***PRELIMINARY
INDEPENDENT REVIEW***

GLEN INNES WIND FARM PROPOSAL

***Prepared for
NSW DEPARTMENT OF PLANNING
& ENVIRONMENT***

**8th August 2018
REF: 974-Z1-04
REVISION: Final**

Figure 1 GIWF Approved Mod-2 and proposed Mod-4 layout

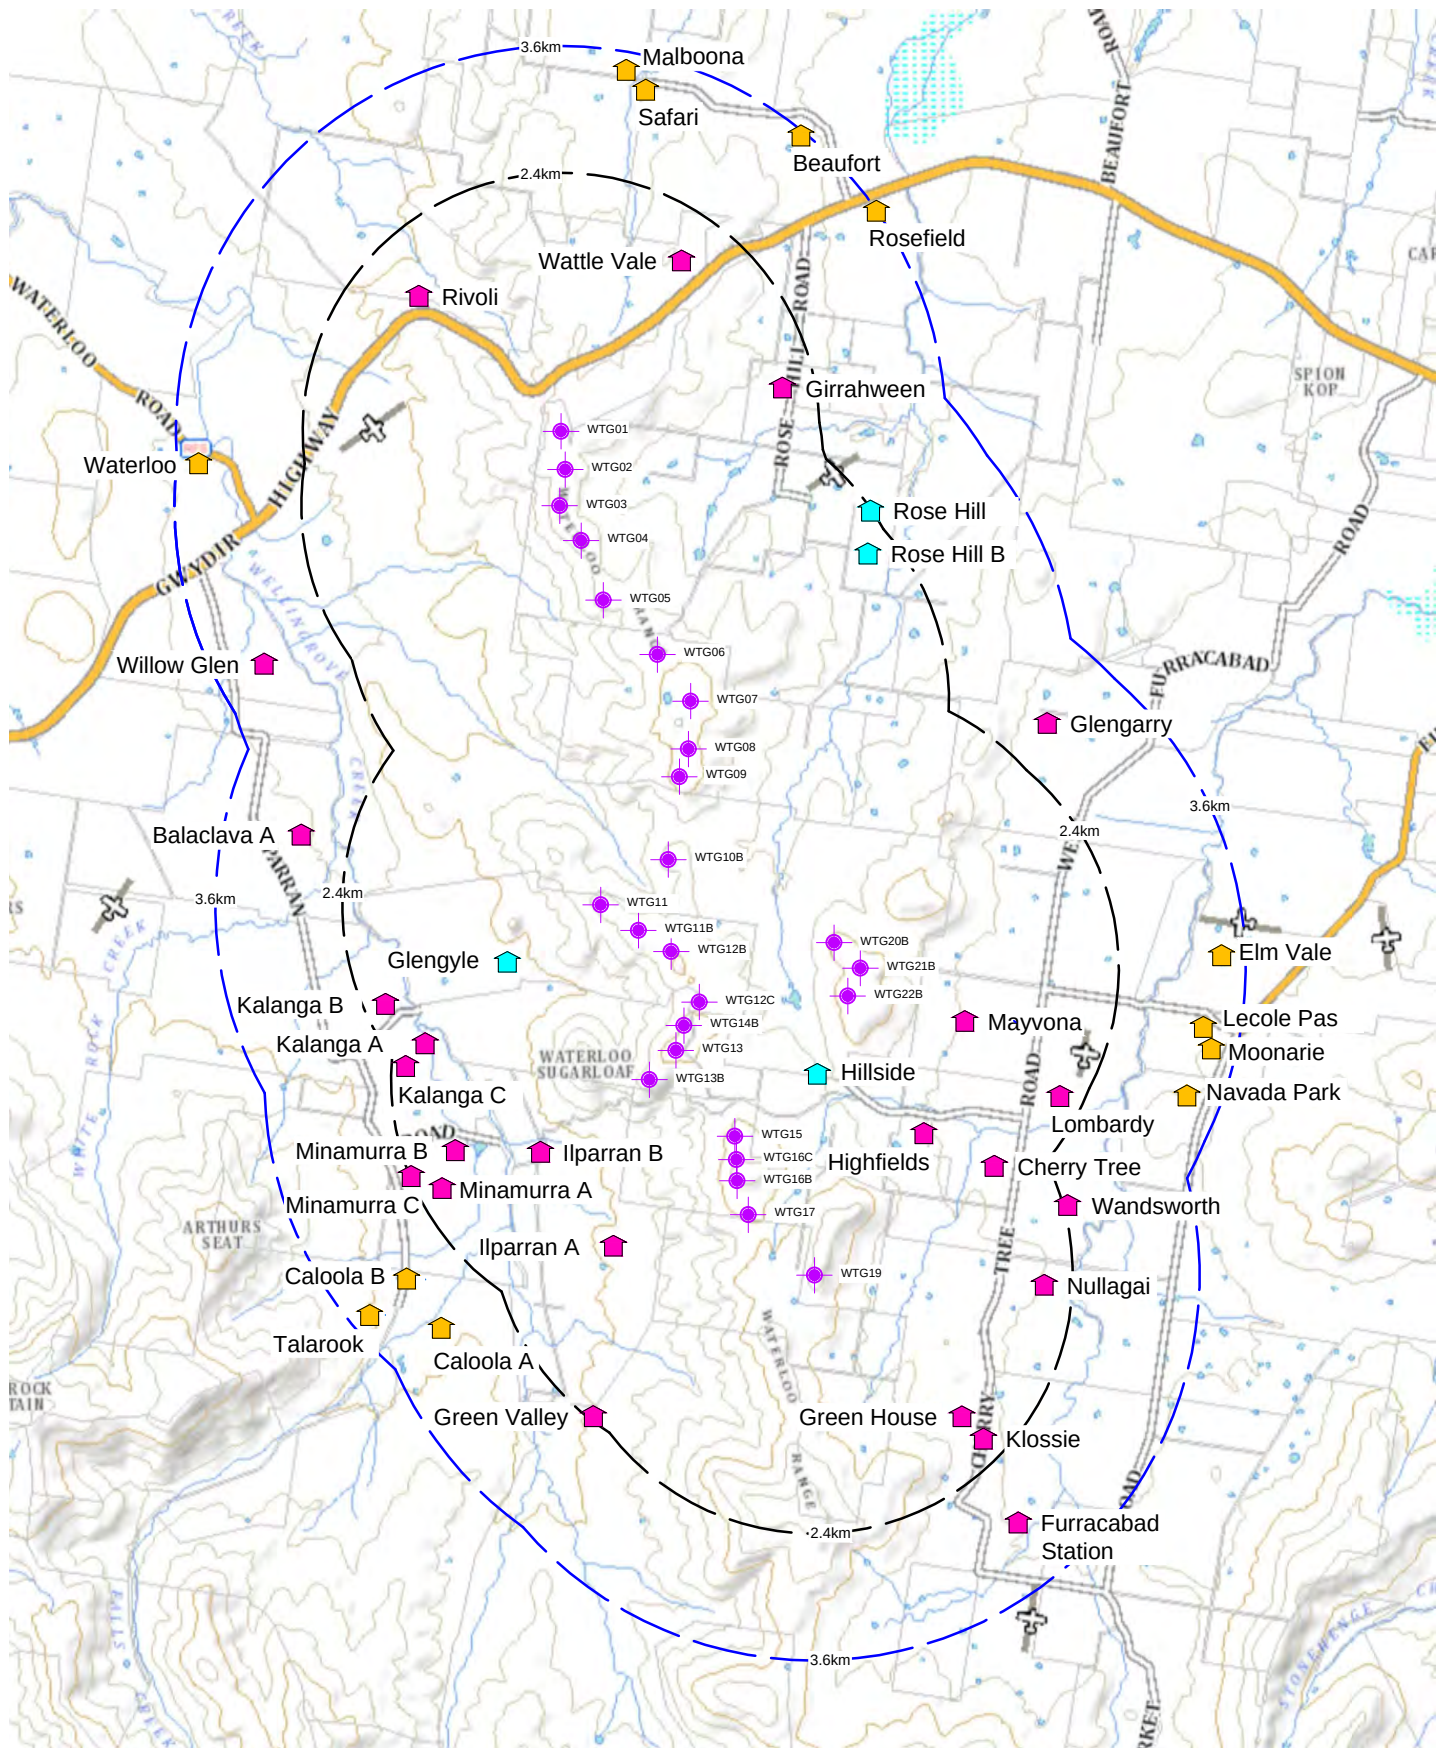
- Any residence that received a high rating in the Green Bean modification 2 assessment have remained unchanged in the Modification 4 assessment. This creates the impression that the overall impacts of these residences have not changed. In fact, in most cases an increase of 20% in turbine height would increase the impacts at these residences and this is evident in the increase of viewable tips and hubs from these residences. However, as these residences are already rated at high and the rating system does not allow for any rating in excess of high, their ratings have remained unchanged. Were the rating system used more finely grained, it could be expected that at least some of these residences would see an increase in their overall visual impact rating.

An example of this lack of refinement in the rating system can be seen in the table immediately following **(Section 3.1)**. Girraheen was previously rated as high in the Mod 2 assessment. In Mod 4 the height of turbines has increased by 20% (30m). This has resulted in an increase from 14 to 22 visible hubs whilst the Mod 4 LVIA rating for this property remains at high as there is no potential to increase past this rating.
